Single storey front & rear extension. Roof alterations to create 1st floor accommodation including new half hips to gable end walls and dormer windows to front and rear elevations.

9 Sark Gardens Ferring

Thank you for your internet comments made on 8th February 2010 and recorded as follows:

ROOF PLAN
1:200

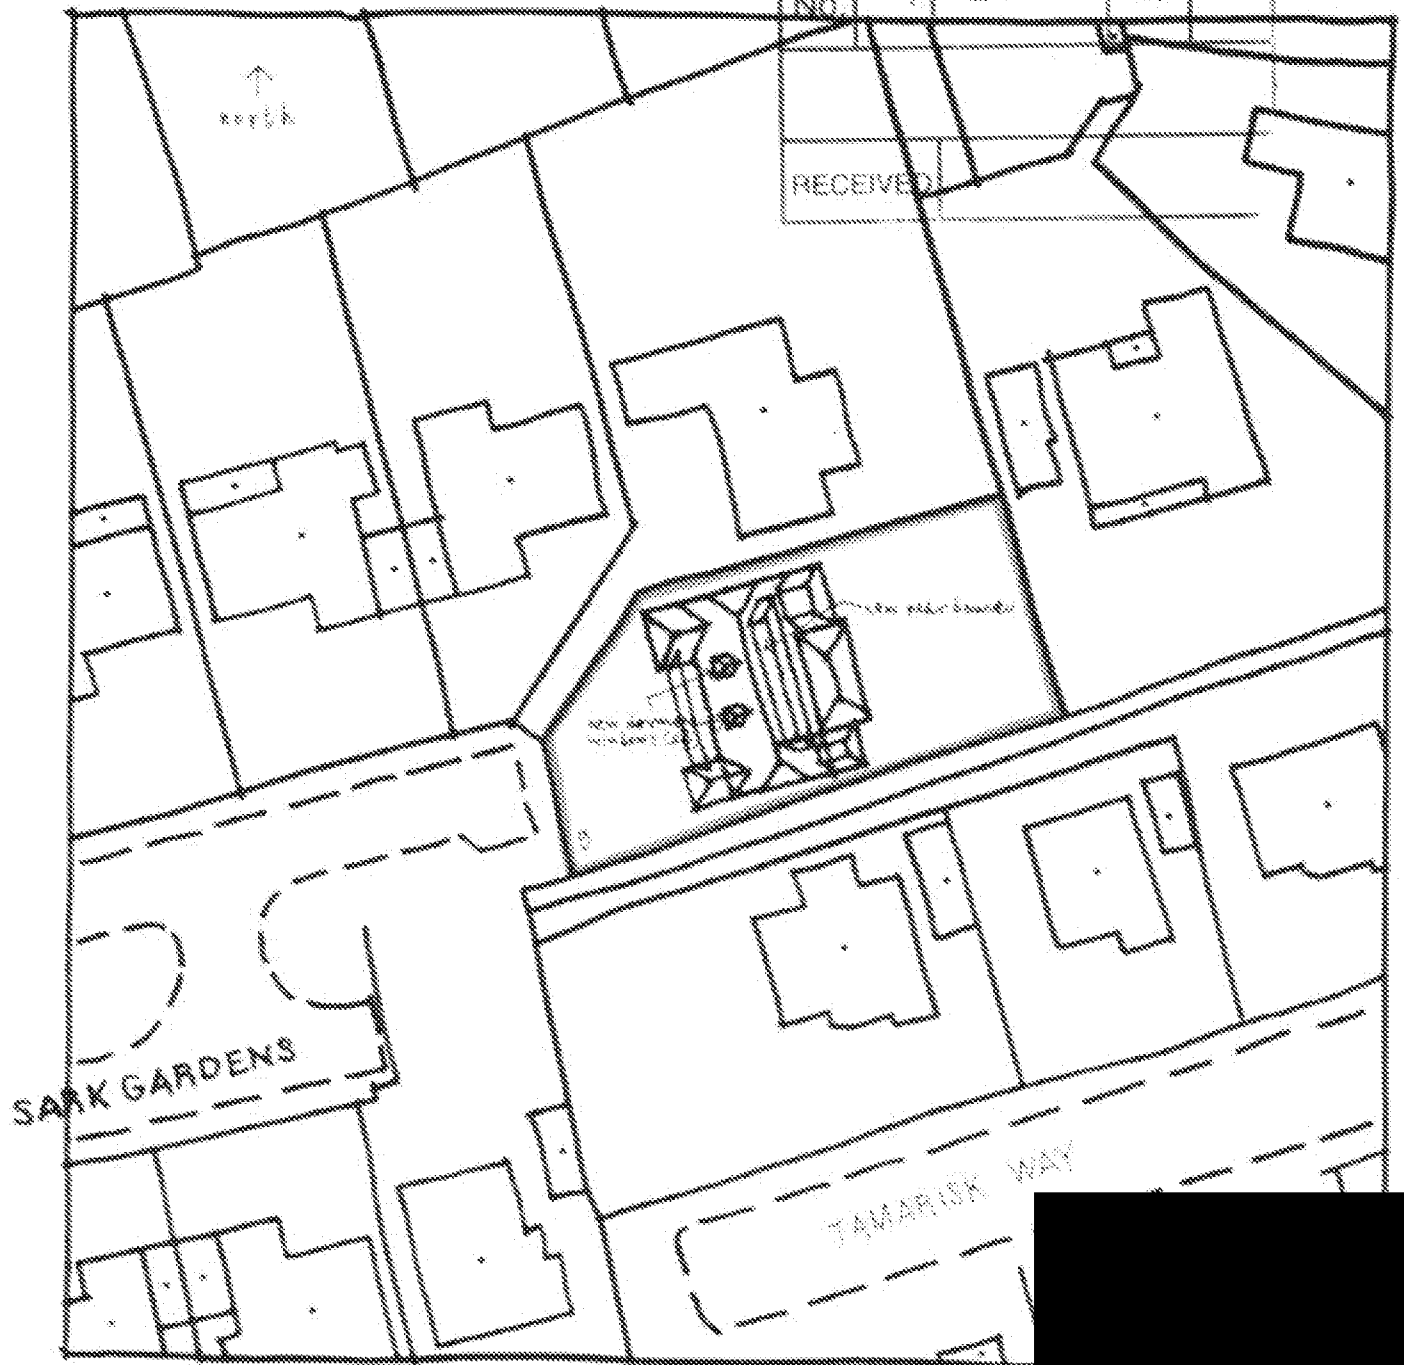
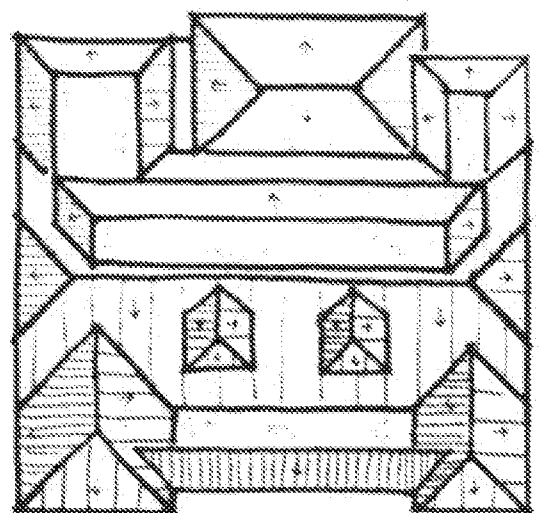
☐ *The provision of an increased roof area would doubtless cause further strain on an already inadequate surface water disposal system in this area and would be contrary to the provisions of Policy GEN 9 of the ADLP.* ☐

PROPOSED ELEVATIONS 1:100

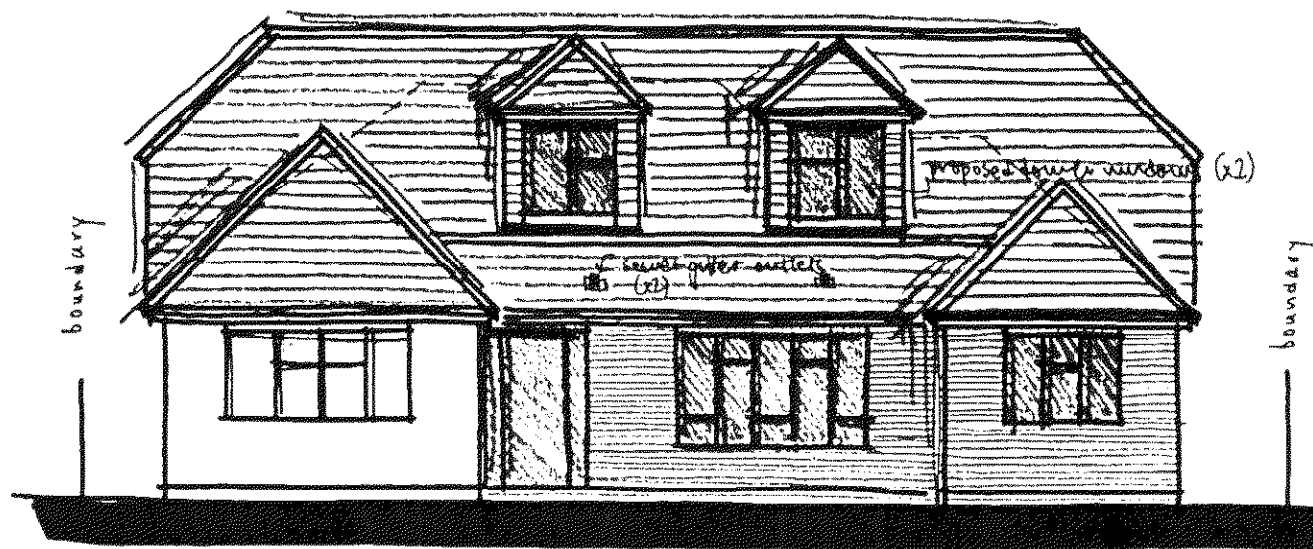
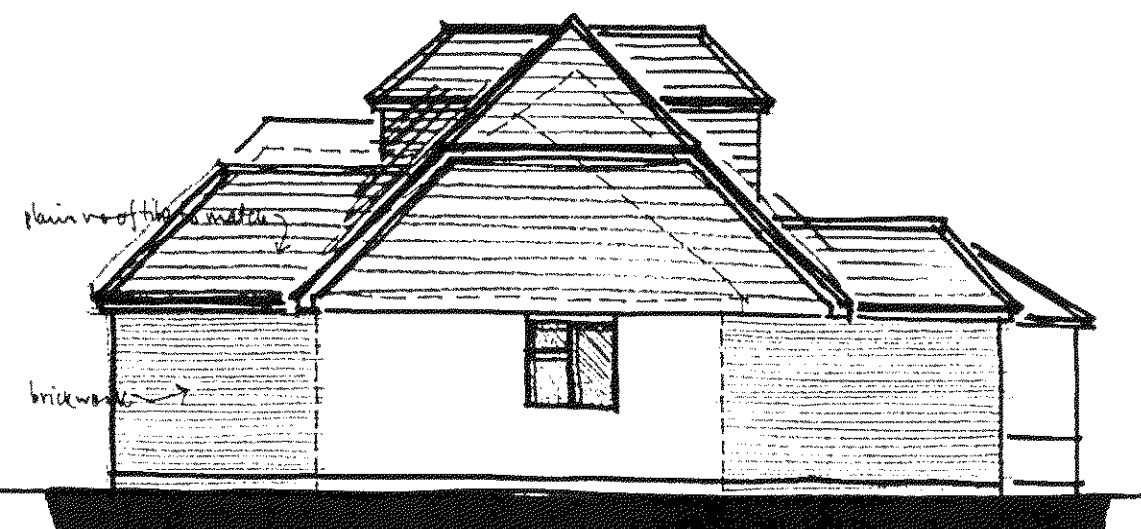
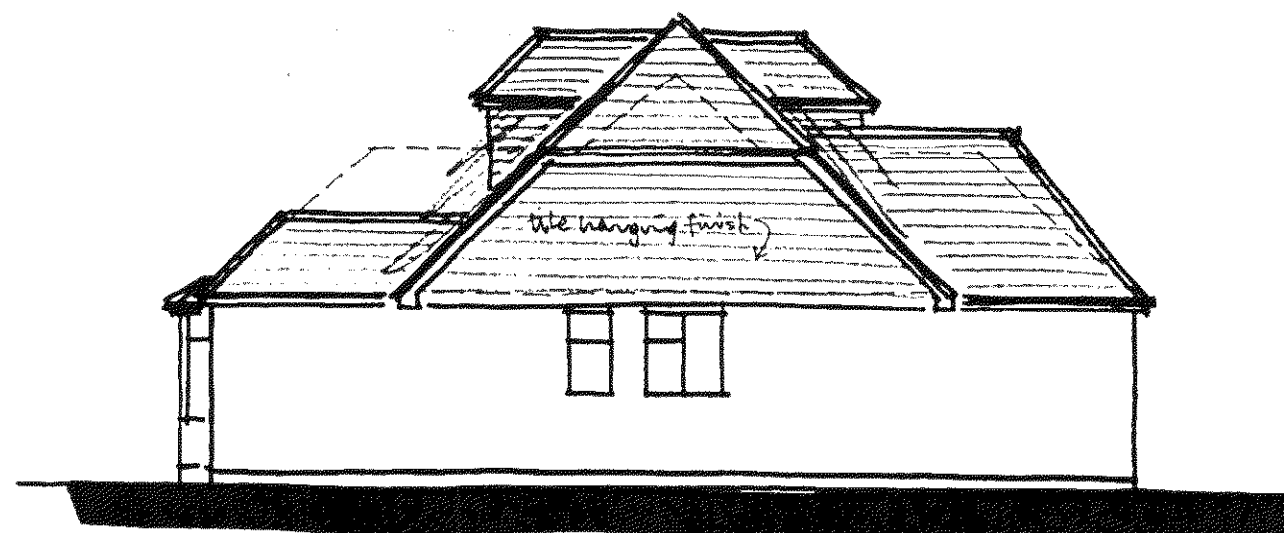
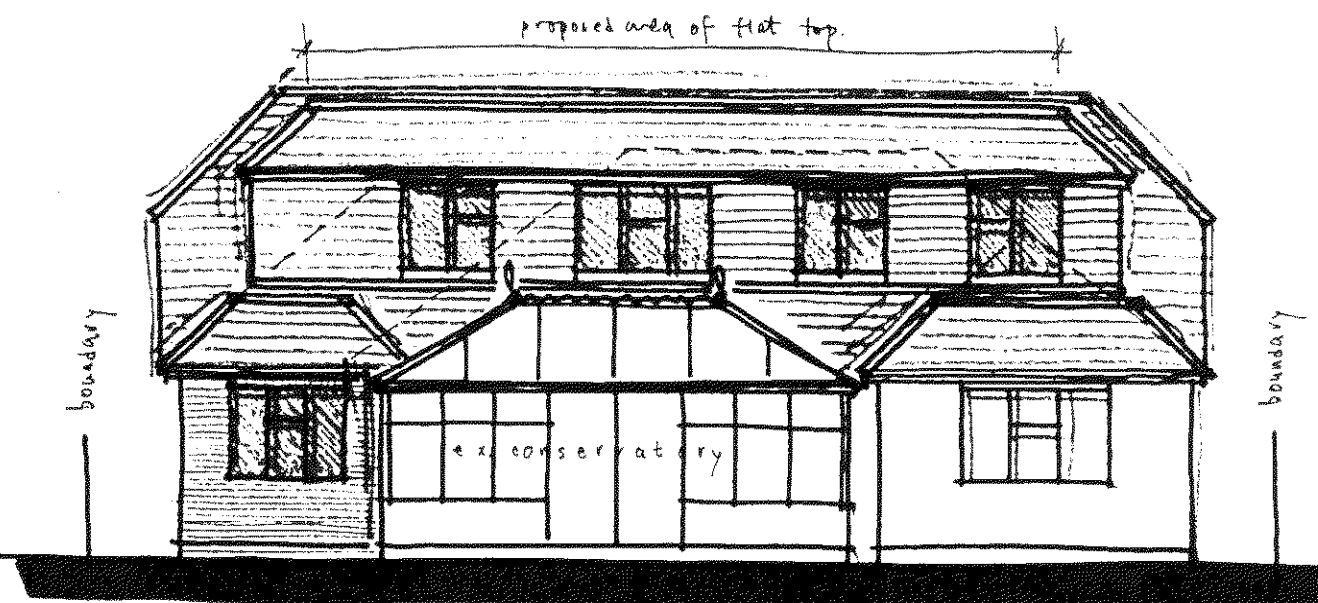
The revised proposals do not materially differ from those previously refused and Ferring Parish Council reiterates its strong objection to them in that the proposed extension and alterations to the roof would not be in accordance with the characteristics of the surrounding area and would be overbearing in the small close where the buildings are predominantly bungalows. The nature of the area is such that the existing buildings are in close proximity to each other and the provisions of a high roof containing dormer windows would have an adverse impact on the adjoining premises in that they would overlook several gardens. All in contravention of the provisions of Policy GEN7 & DEV 19 of the Arun District Local Plan. ☐
